Rezoning Transportation Analysis

Petition Number: #2022-175

Date	Description
02-22-23	First Review (TM)

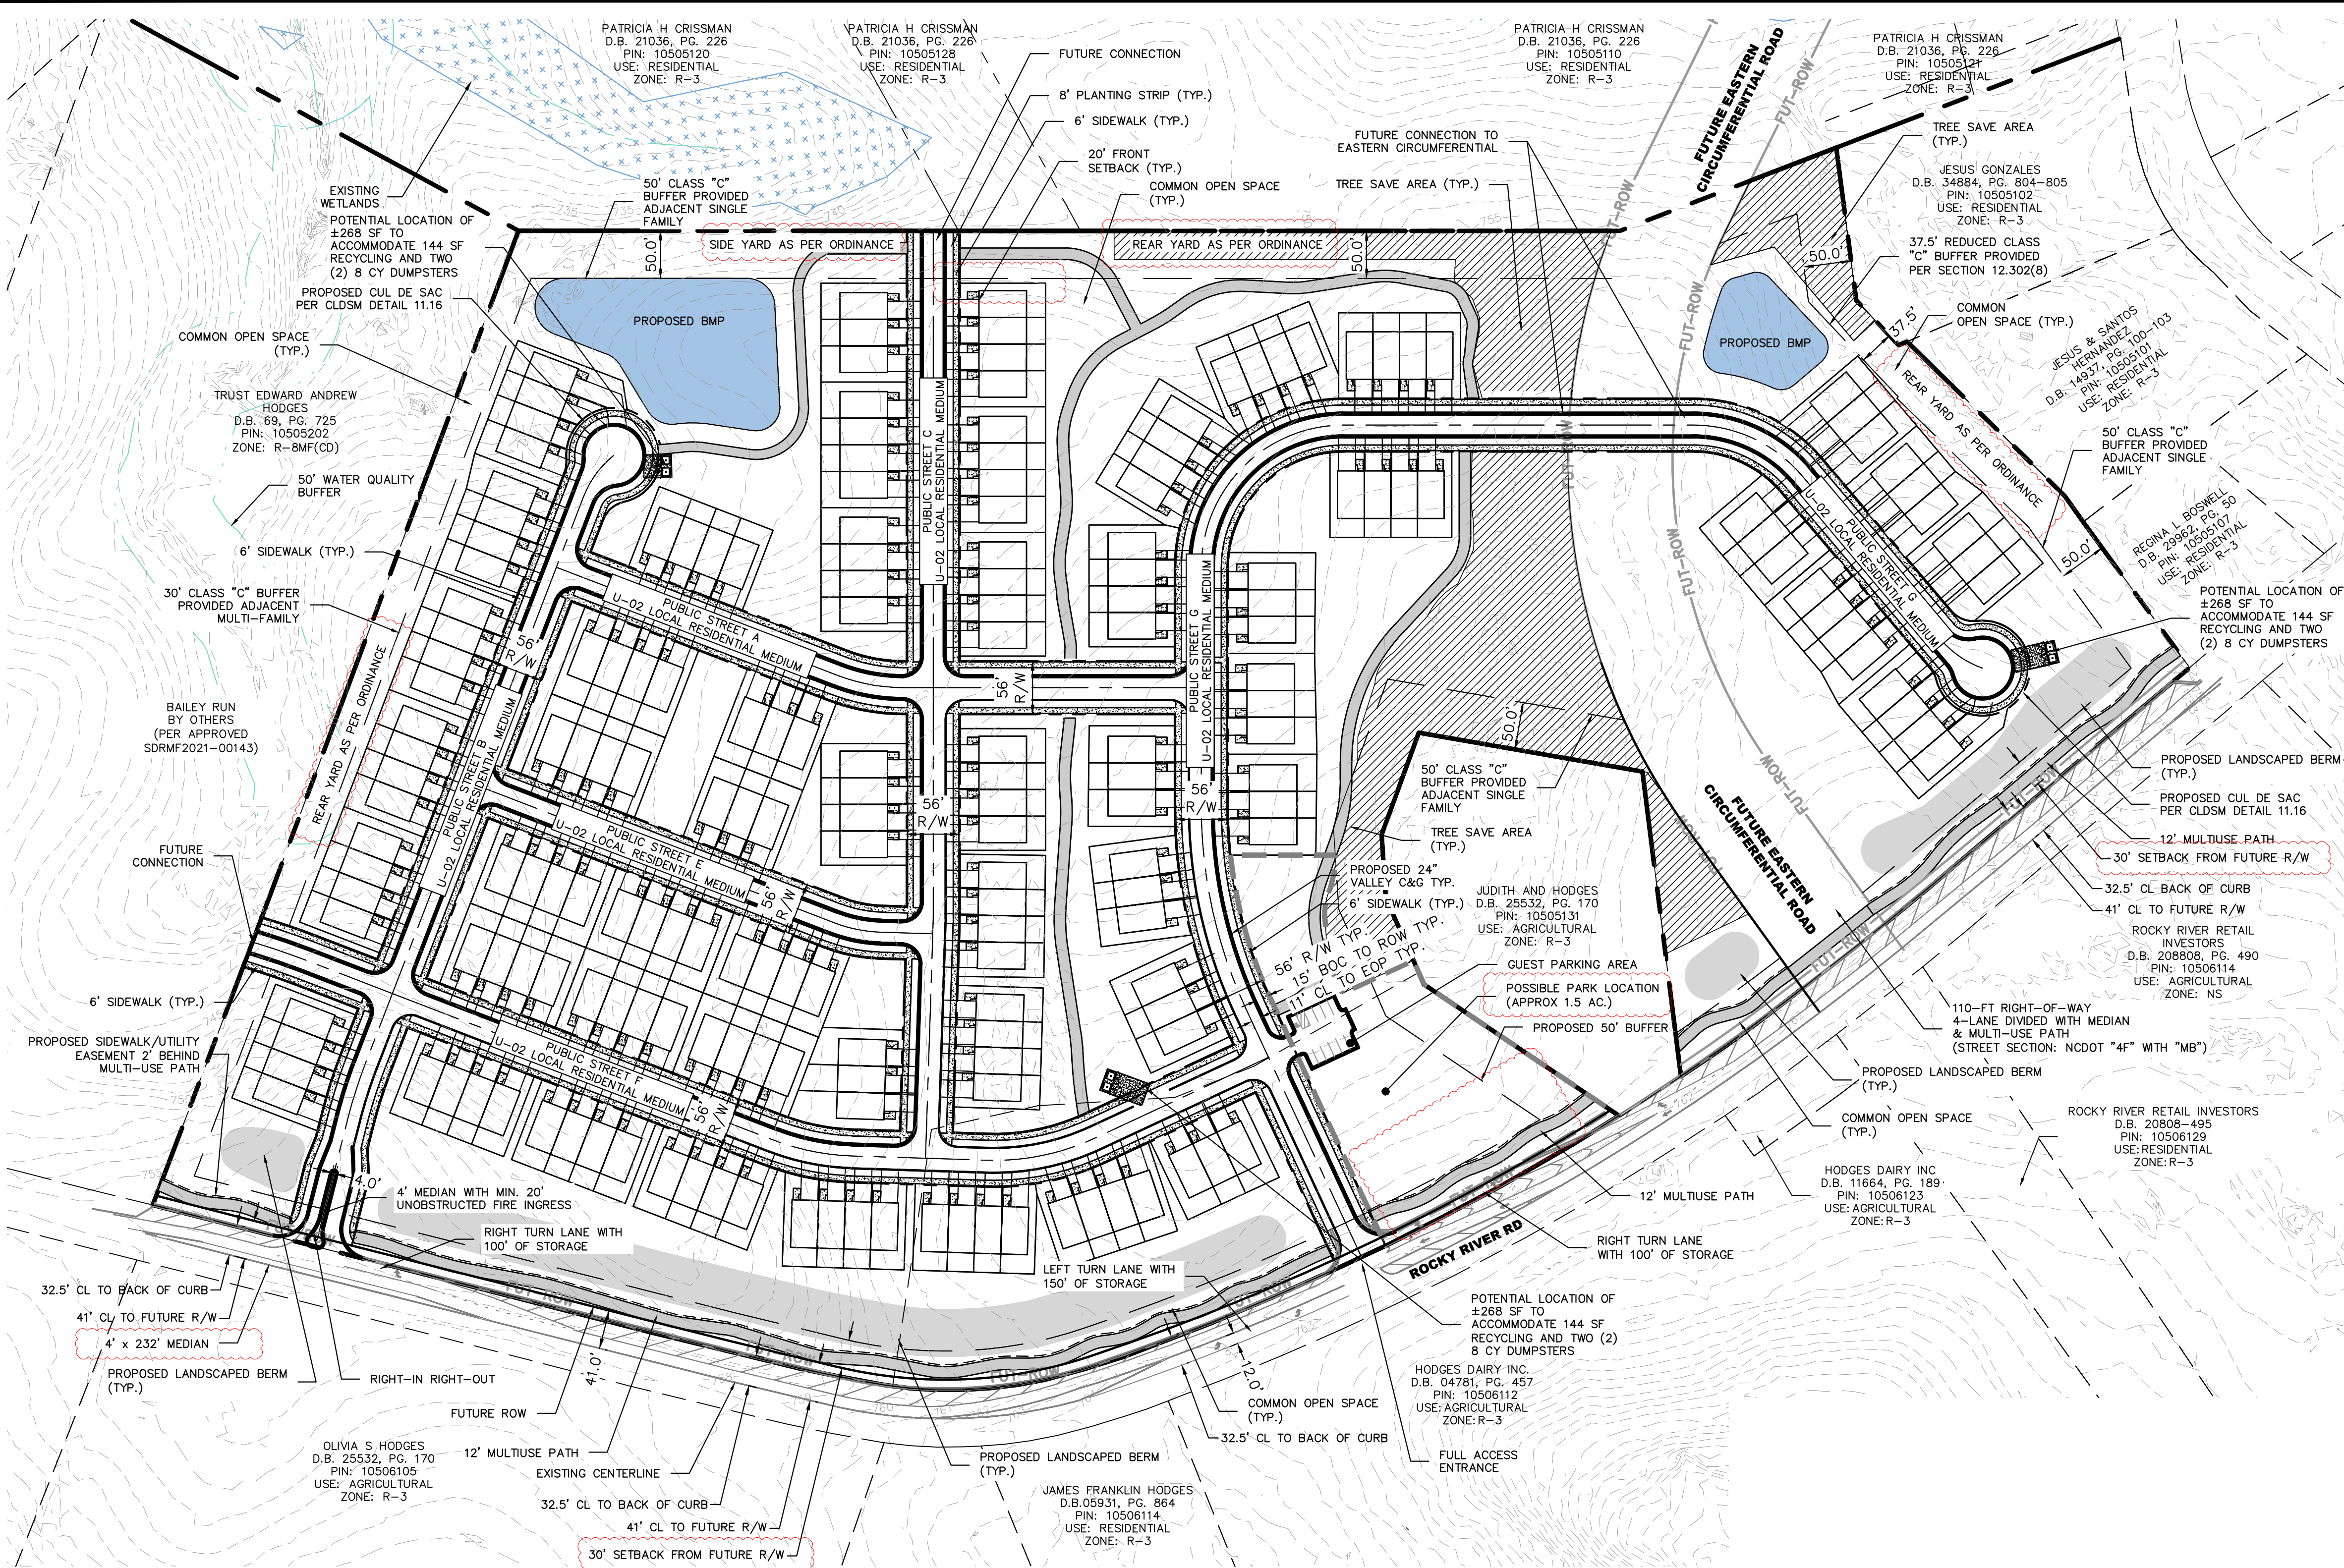
- a. **Rocky River Road:** Location of curb and gutter to be moved to 30-feet from roadway centerline to accommodate the Charlotte Streets Map with a roadway typical section of 4+ Avenue and Shared Use Path.

Outstanding Comment from 02-22-23: Label and dimension the curb and gutter from the centerline for each road on the site plan.

- 3. **Outstanding Comment from 02-22-23:** The site plan shall label and dimension the right-of-way from the road centerline.

9. **Outstanding Comment from 02-22-23:** Revise site plan and conditional note(s) to commit to constructing Public Street B as right-in right-out access point. Widen Rocky River Road to install a dedicated right turn lane into the site with 100-feet of storage in coordination with NCDOT.

Clarifying Comment from 03-23-23: Right-in/Right-Out will require 4' median extending 50' past radius of curb return on either side of driveway. Label and Dimension median and turn turn lane on site plan.

10. **Outstanding Comment from 02-22-23:** Revise site plan and conditional note(s) to commit to widening Rocky River Road to construct a dedicated left turn lane with 150-feet of storage and a right turn lane with 100-feet of storage at Public Street G in coordination with NCDOT.

Clarifying Comment from 03-23-23: Label and Dimension turn lanes on site plan.

15. Revise site plan and conditional note(s) to construct 8-foot planting strips and 12-foot multi-use paths on Rocky River Road. The site plan shall label and dimension both items from the back of curb and gutter or edge of pavement. Add conditional note The entire facility must be outside of the right of way
